RMG Response Letter to—Development Plan and Final Plat for Northcrest Flex Space PPR

PCD File No.: PPR-21-036

Sixth Review Letter

Subject: Northcrest Flex Space
2510 and 2522 Canada Drive
Colorado Springs, CO 80922

ARCH/ENG	MDT	
DRAWN	CL	
CHECKED	MDT	
DATE		
8-02-22		
#	REVISION	DATE
1	WALL DETAILS	12-21-22
JOB NO.	180649	
SHEET NO.	S1

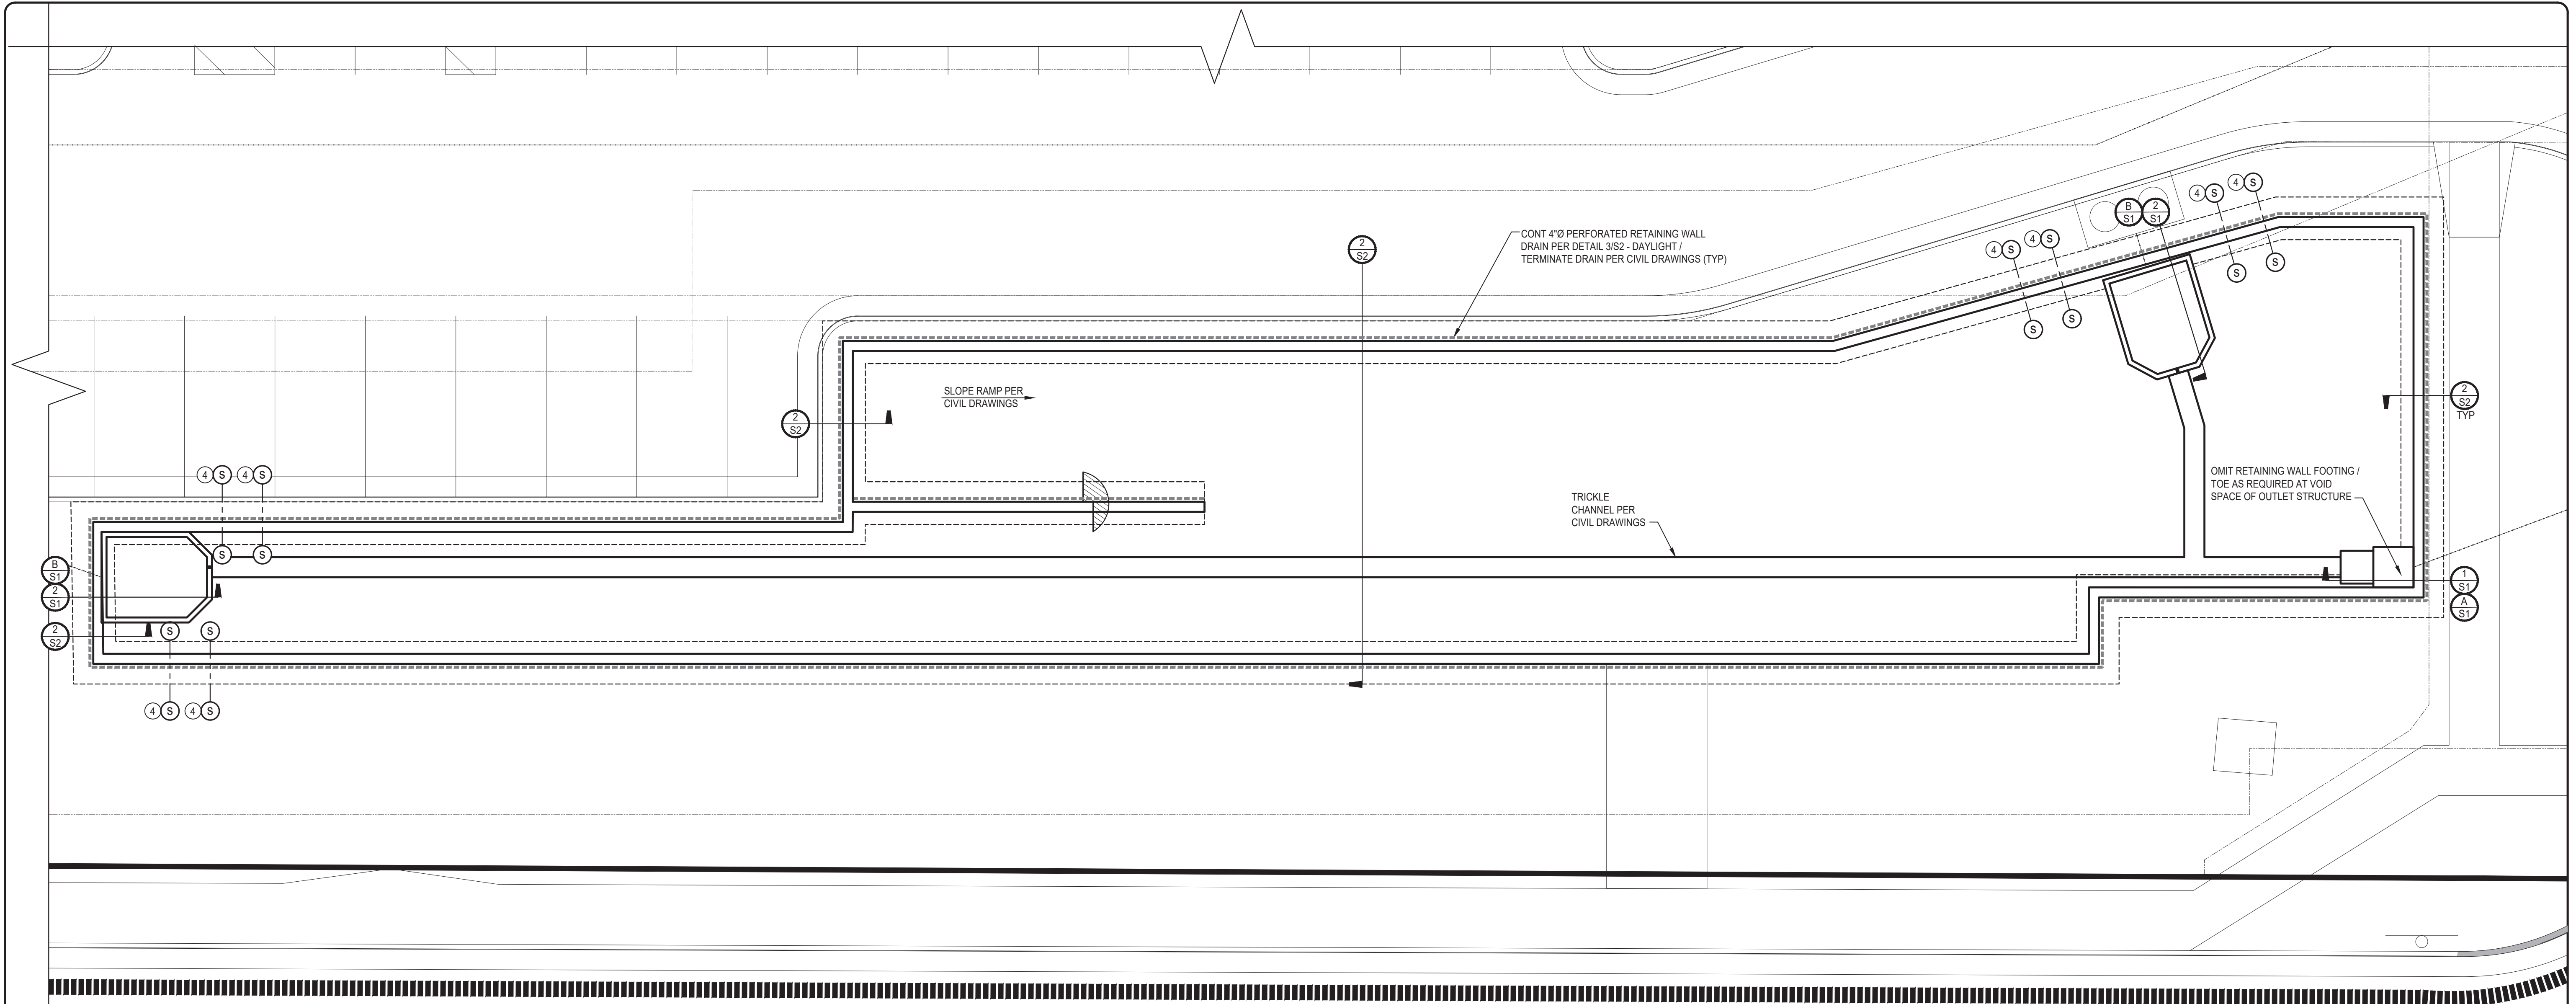
26. There should be a micropool here

27. I don't see this cross section

28. I don't see this cross section

29. Show dimensions somewhere. Here or 2/S1

30. Micropool is missing.

31. Regional building Department permit required for all retaining walls greater than or equal to 4ft in height.

32. Provide details for tie in to existing inlet and at what elevation

33. Update to show vegetated pond bottom.

34. The GEC shows the forebay as having a slope from 1.5' to 8" H. Then, based on the cross section location, there should be a 3" depression.

RMG: This has been revised

RMG: Same both ways, typ.

RMG: Same both ways, typ.

RMG: Dimensions shown on structural plans

RMG: This has been revised.

RMG: These are the plans that will be submitted to PPRBD for the permit.

RMG: These details are provided on the civil detention basin plans.

RMG: This has been revised.

RMG: This has been revised.

1 DETENTION BASIN STRUCTURAL PLAN
S2 SCALE: 1/8" = 1'-0"

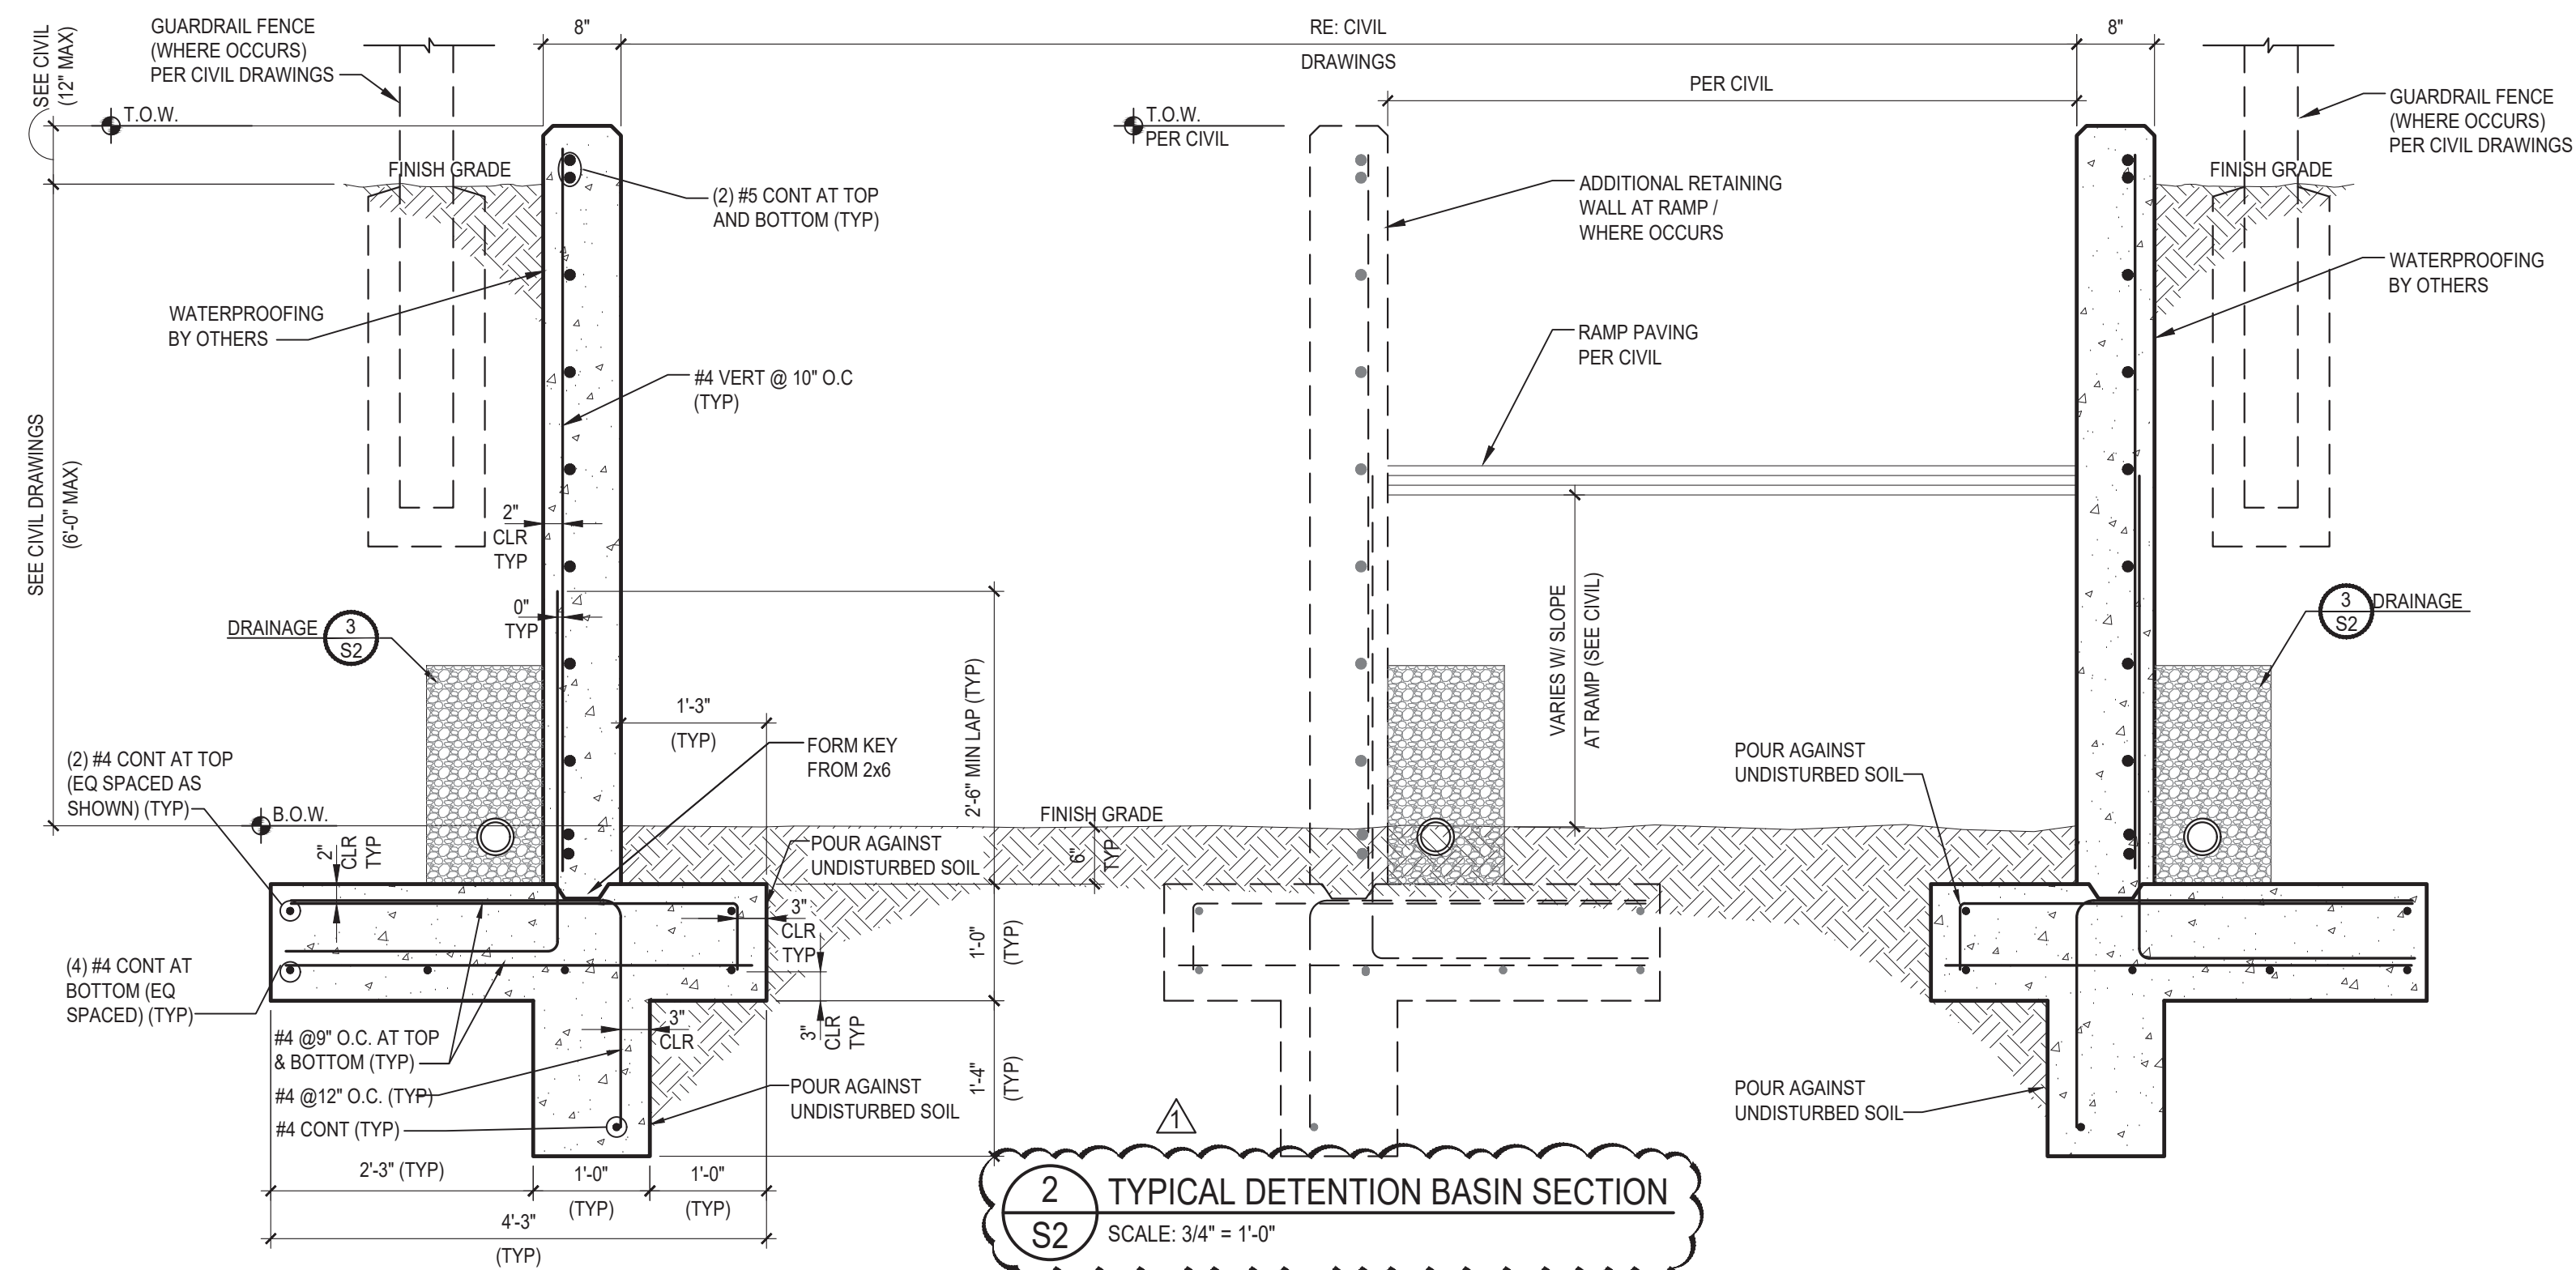
35. Show location of drainage pipes and where they tie into. How much flow are you expecting? Discuss further in the drainage report.

36. Show Handrails

37. Pending pond design V6 showing grass lined bottom. Spoke with RMG Architect on 12/14/22

38. Per ECM 2.6.7.E Please add pedestrian safety metal railing along sidewalk area and along parking areas. Pedestrian railing height shall be a minimum of 42 inches, measured from the walkway surface (See Figure 2-45). Railings shall not have openings large enough to pass a 4-inch sphere. Please show design detail of the steel railing to be used and indicate either on the SDP, GEC plan or the pond design CDs the where railing will be placed. The cedar split rail fence may be used on the south side of the detention pond

RMG: This has been discussed in the drainage report.

RMG: This has been revised.

RMG: Grass lined bottom on pond has been shown.

RMG: This has been revised.

ENG:	DGW	
DRAWN:	TPT	
CHECKED:	DGW	
DATE:	12/07/2022	
#	REVISION	DATE
JOB NO.:	180649	
SHEET NO.:	C-04	
of 12

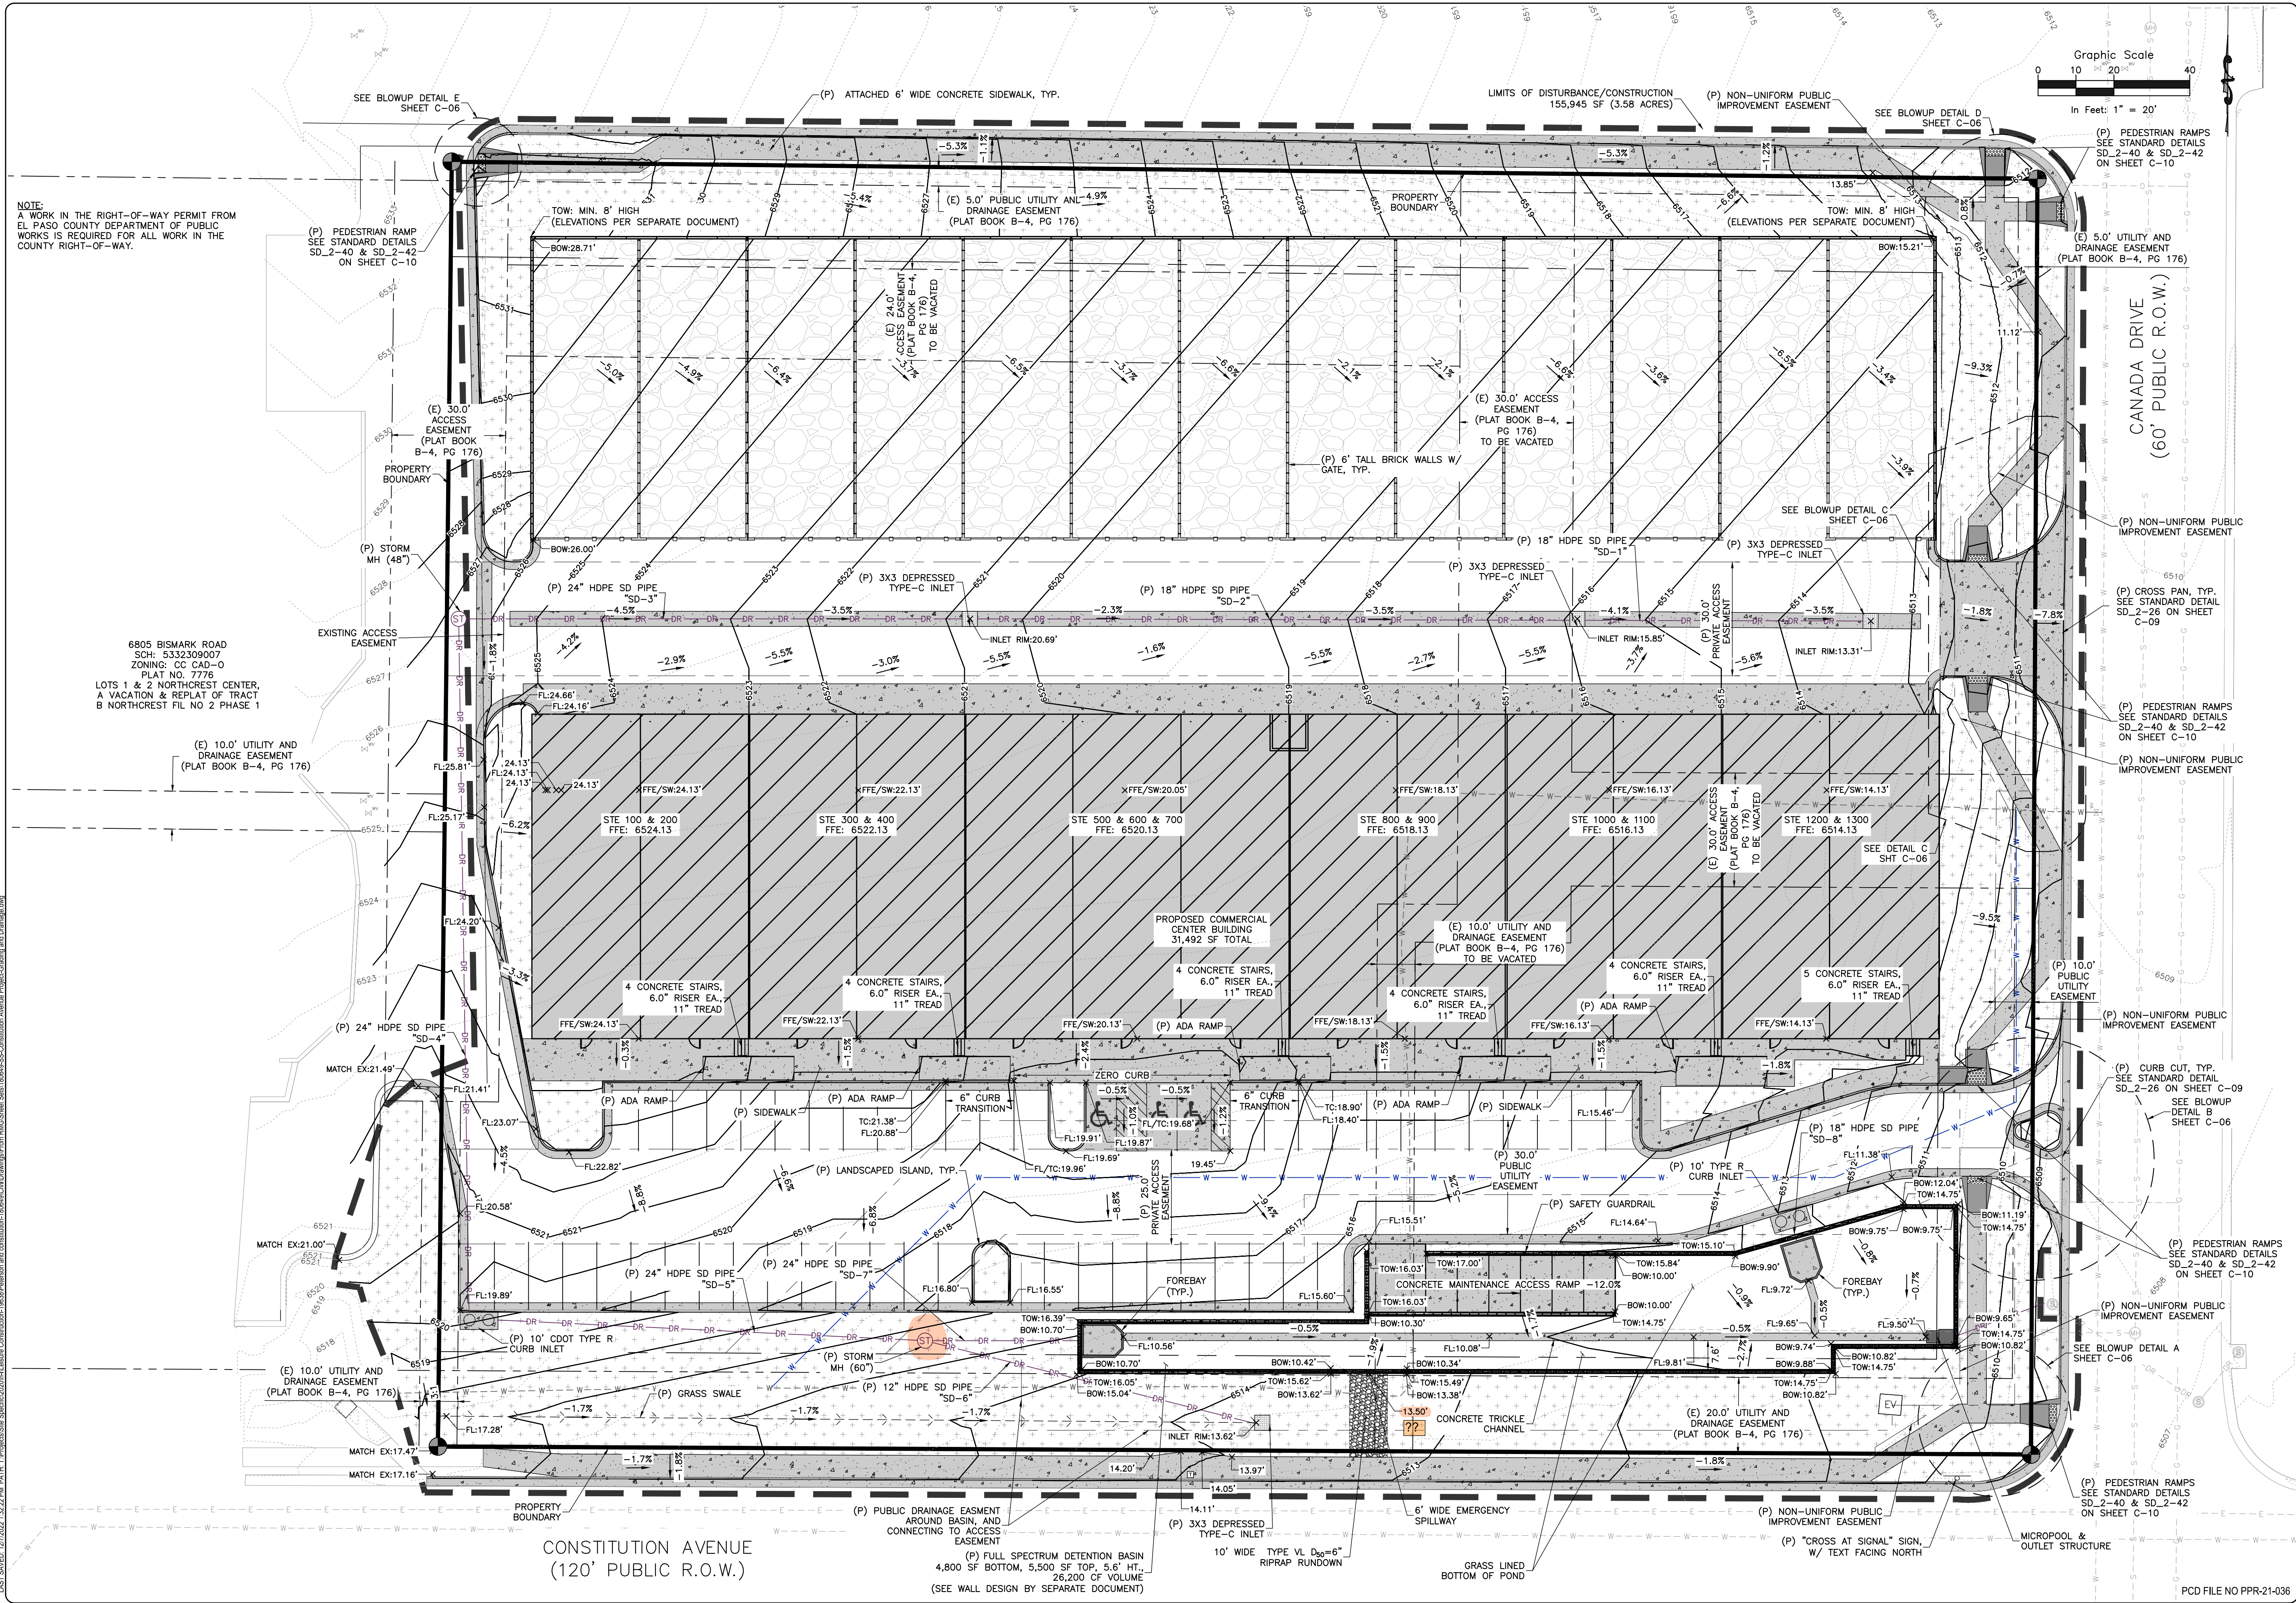
1. Add permanent seeding to pond bottom.

RMG: This has been labeled.
